COLORADO GEOLOGICAL SURVEY

July 19, 2019

**Subject: Trails at Aspen Ridge PUDSP191 (previously reviewed as Springs East at Waterview SP-17-010)
El Paso County, CO; CGS Unique No. EP-18-0011 5**

GR01

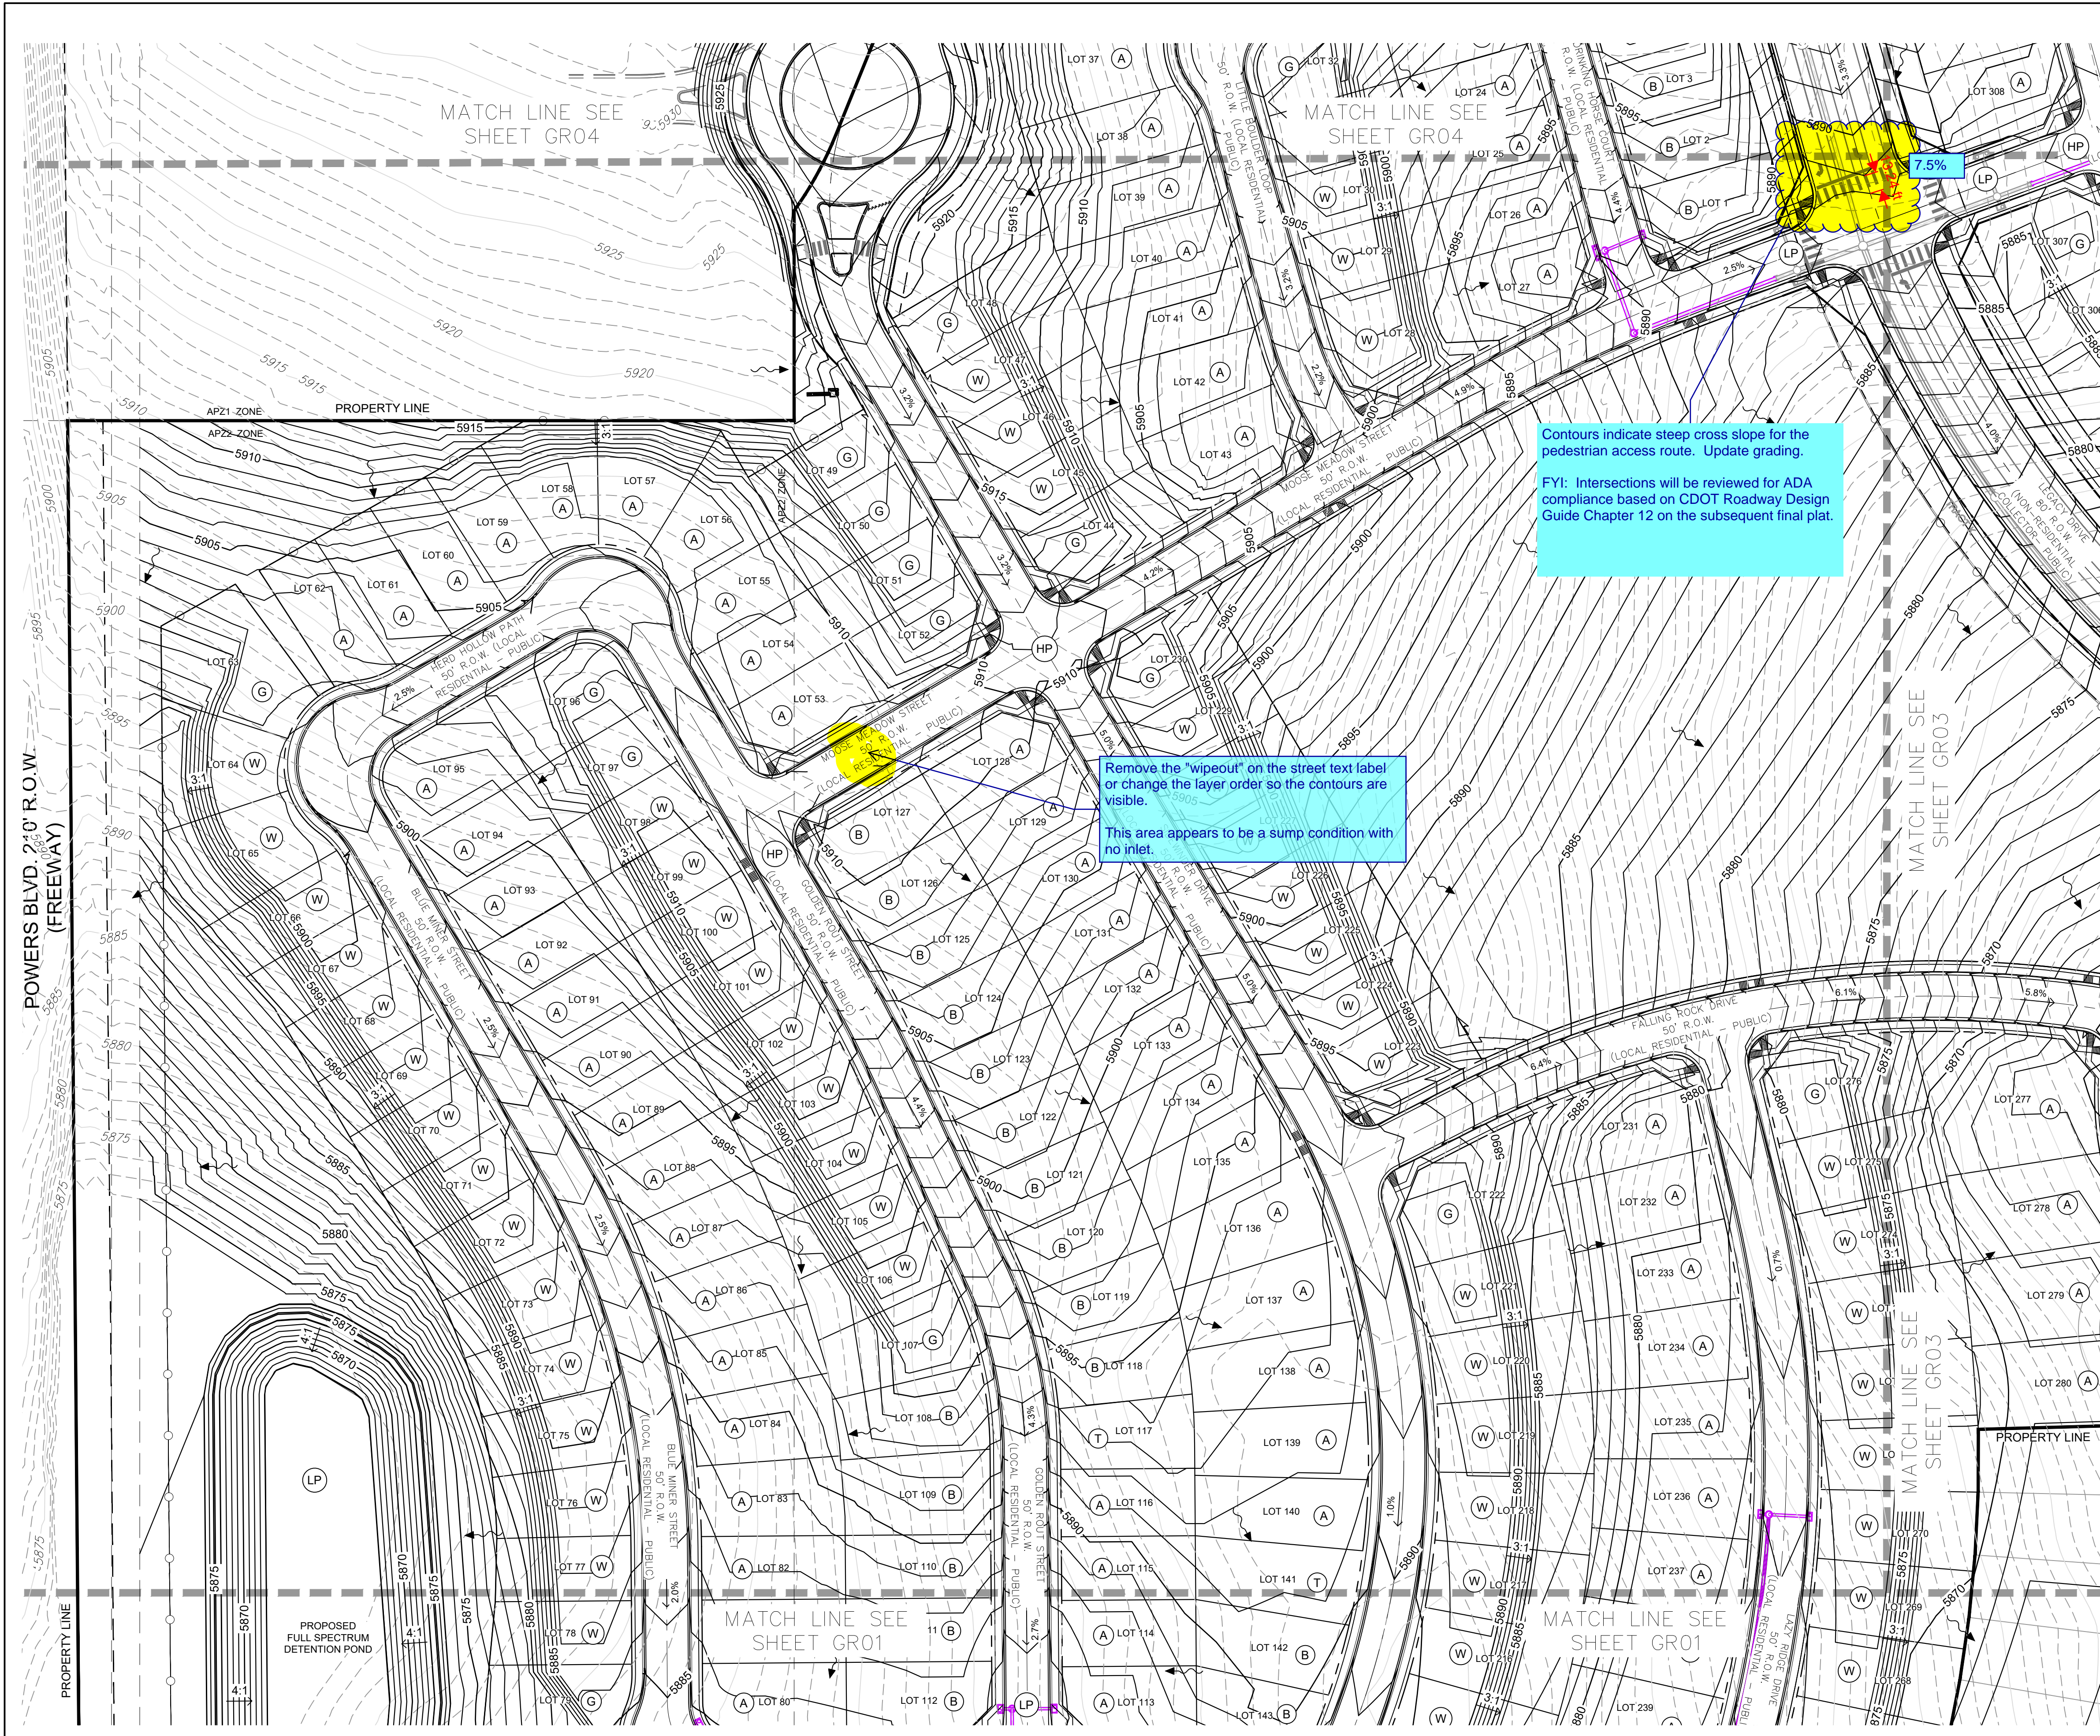
Entech's Appendix B boring TB-1 is located near the Legacy Drive/Frontside Drive cul de sac where, according to sheet 4 of the June 2019 Grading & Erosion Control Plans, approximately 10-15 feet of fill is proposed. TB-2 is located northwest of the Legacy/Frontside cul de sac, in a commercial area outside of the Trails at Aspen Ridge development area, described on sheet 4 of the grading plans as "unplatted."

Additional investigation, sampling, testing and analysis are needed in proposed areas of cuts exceeding about 8 feet, based on the project grading plans, to characterize subsurface conditions, determine depth and extent of overexcavation, if overexcavation is planned to reduce the use of drilled pier foundations, and to determine basement feasibility where Entech's borings did not extend to sufficient depth below planned basement floor and foundation bearing depths.
